Mr Anthony Russo
Manager Project Approvals
HV Operations Pty Limited
PO Box 315
Singleton NSW 2330

**Hunter Valley Operations South - Modification 5 (PA 06_0261 MOD 5)
Request for Response to Submissions**

21.3.17

Director Resource Assessments

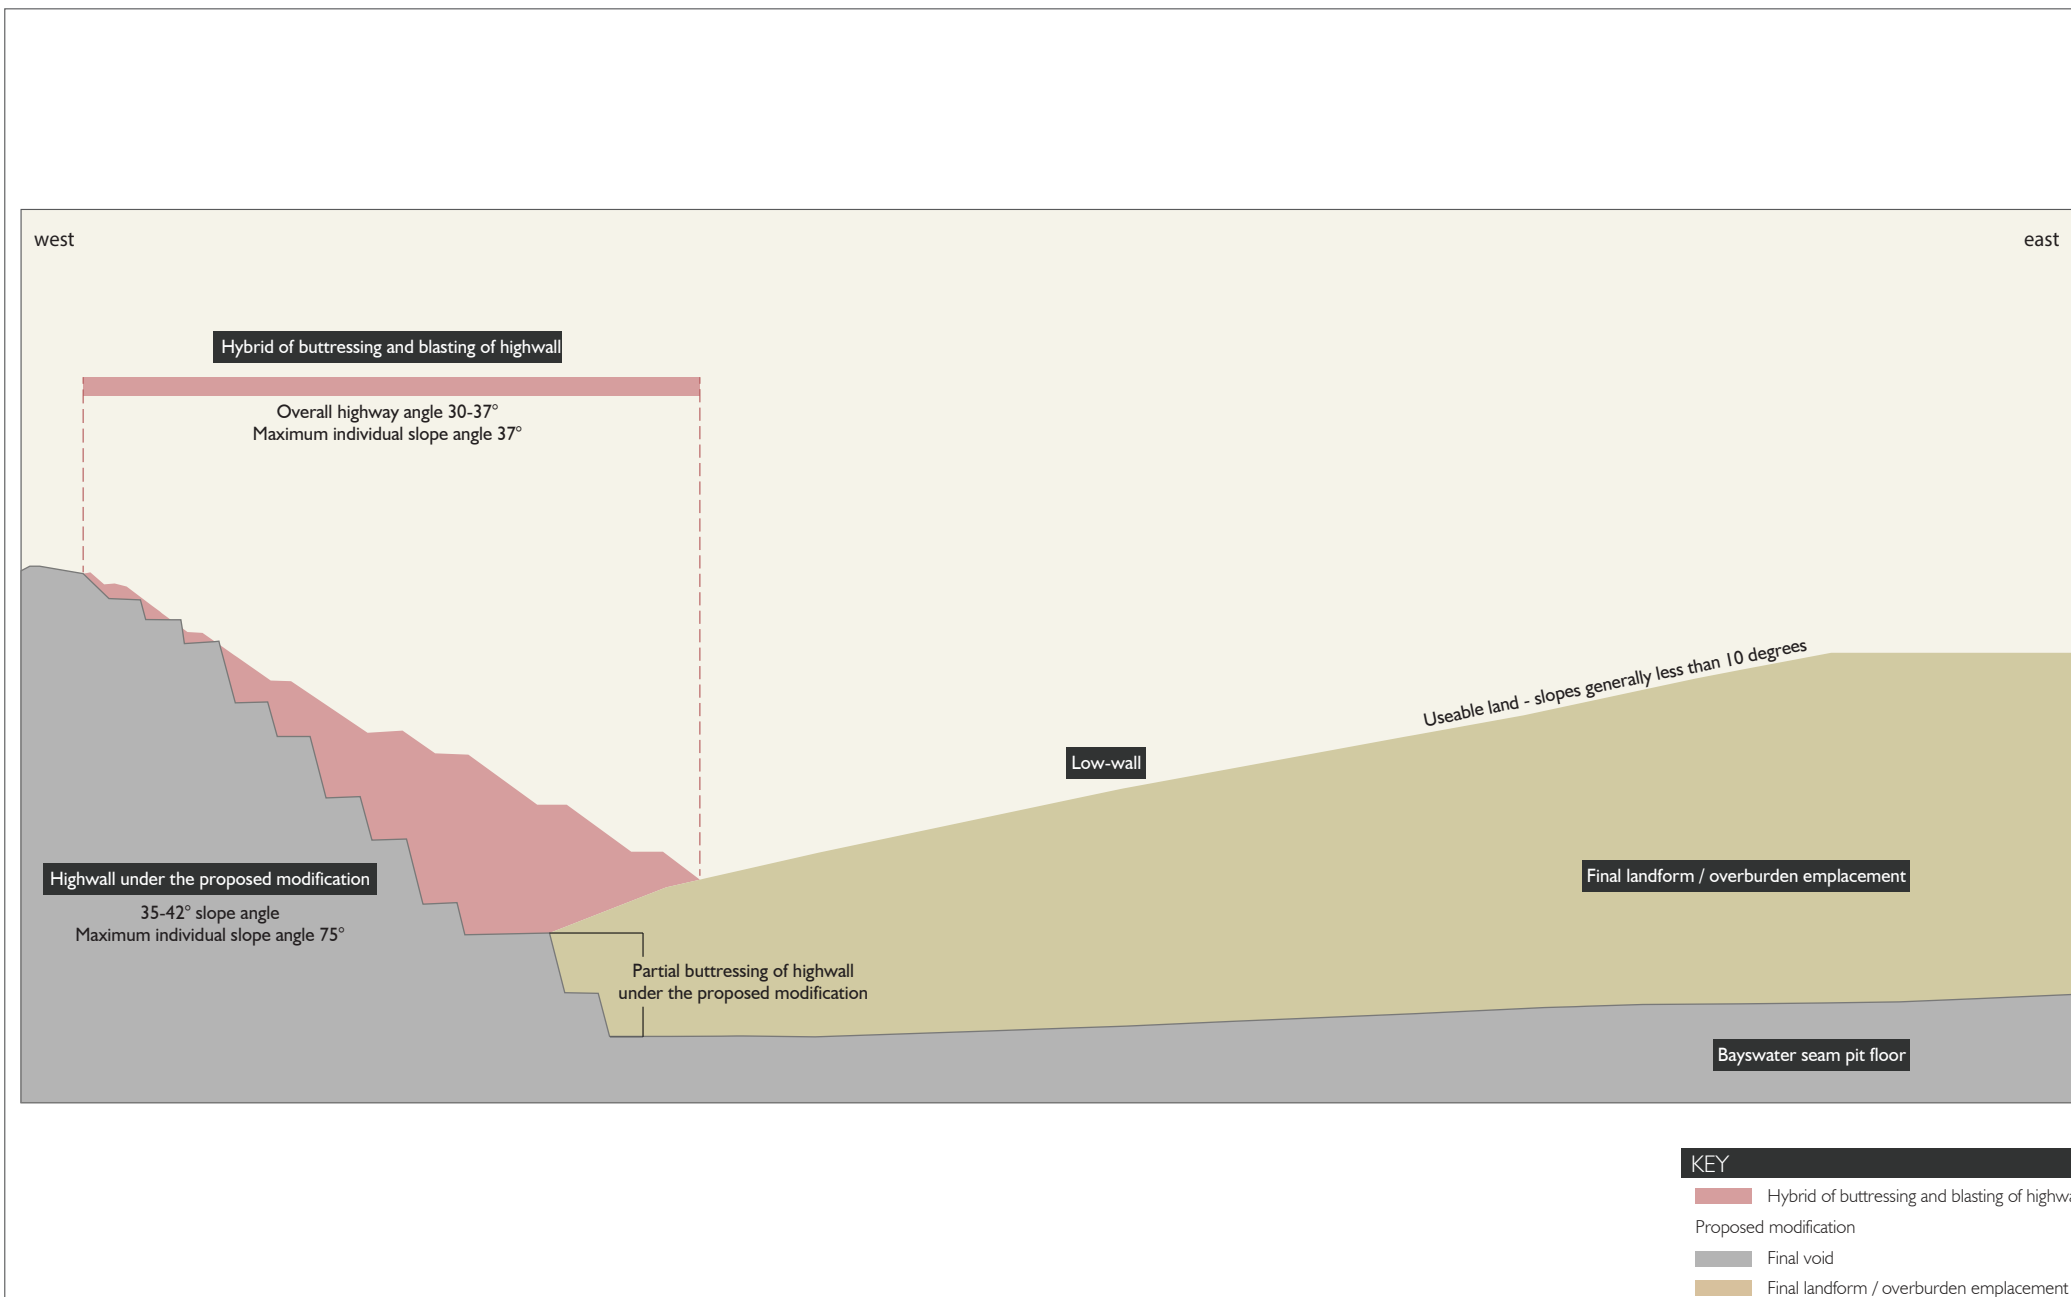
- The Department considers that it may be possible for some additional material to be directed towards reducing the final void or improving its shape and/or slopes. While it is noted that HVO has designed the final void to be further away from the Hunter River, with a smaller surface water catchment, gentler low-wall slopes and more useable surface area, these improvements do not extend to the final highwall. The final highwall slope appears to now be significantly steeper and the southwest corner of the highwall terminates in an almost 90 degree angle (refer to Figure 13.4). Please consider further refinements to make the highwall less angular and more natural in shape. Please also provide further information on the long term stability and safety of this final highwall design.

Overburden emplacement area design high level analysis - proposed modification

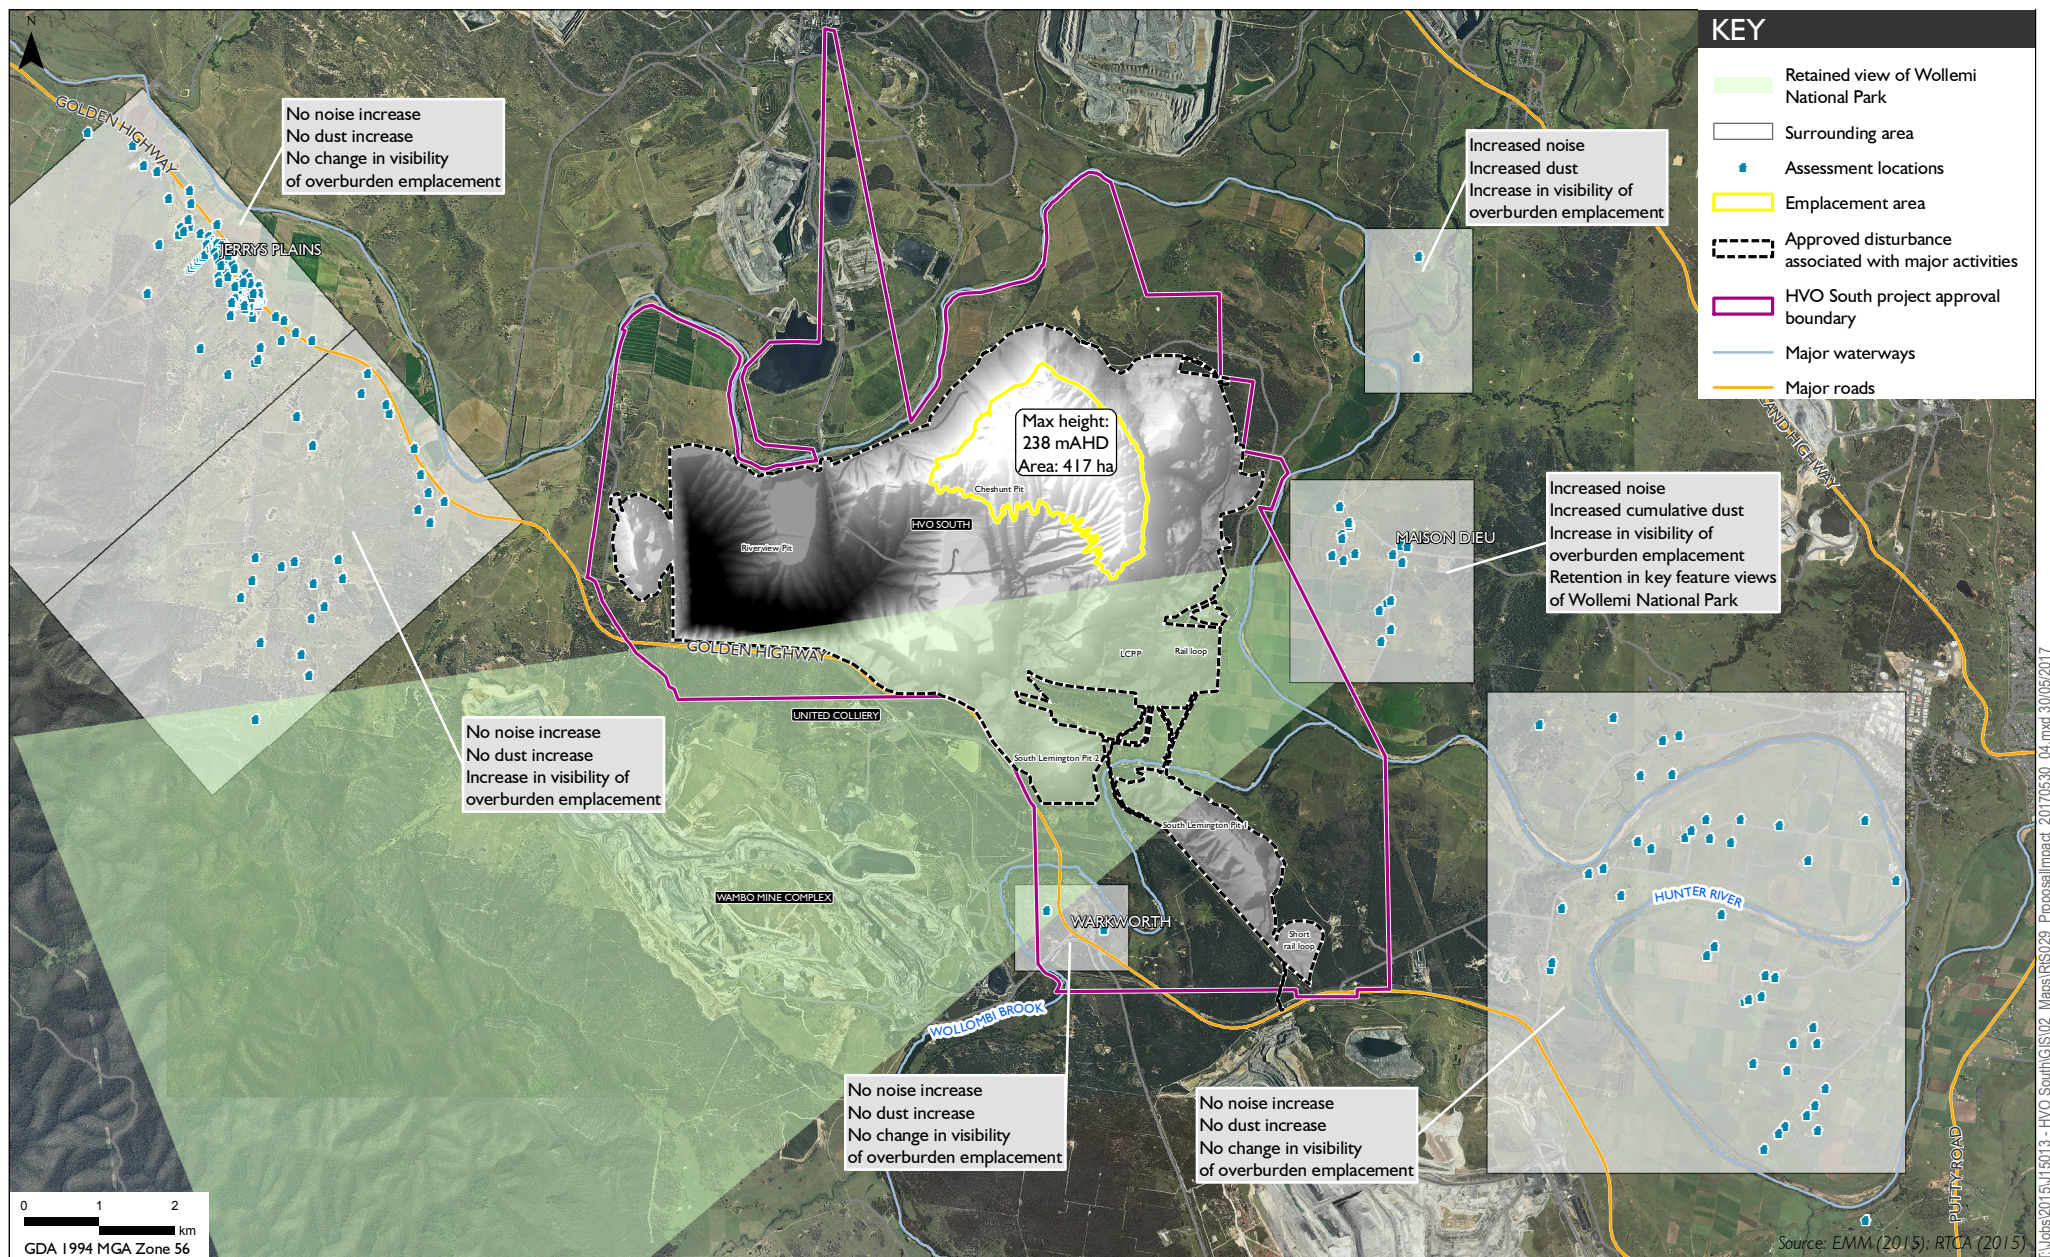
- The Department considers the proposed design is a substantial improvement to the traditional flat tops and uniform slopes. However, the Department requests that HVO consider what opportunities may exist for further refinements, such as incorporating more topographic variation to the external slopes of the emplacement areas to improve visual amenity. For example, the northern area of the Cheshunt emplacement area, with views from Maison Dieu (see Figure 9.3), appears to have been uniformly increased in height with minimal macro relief features built into the design.
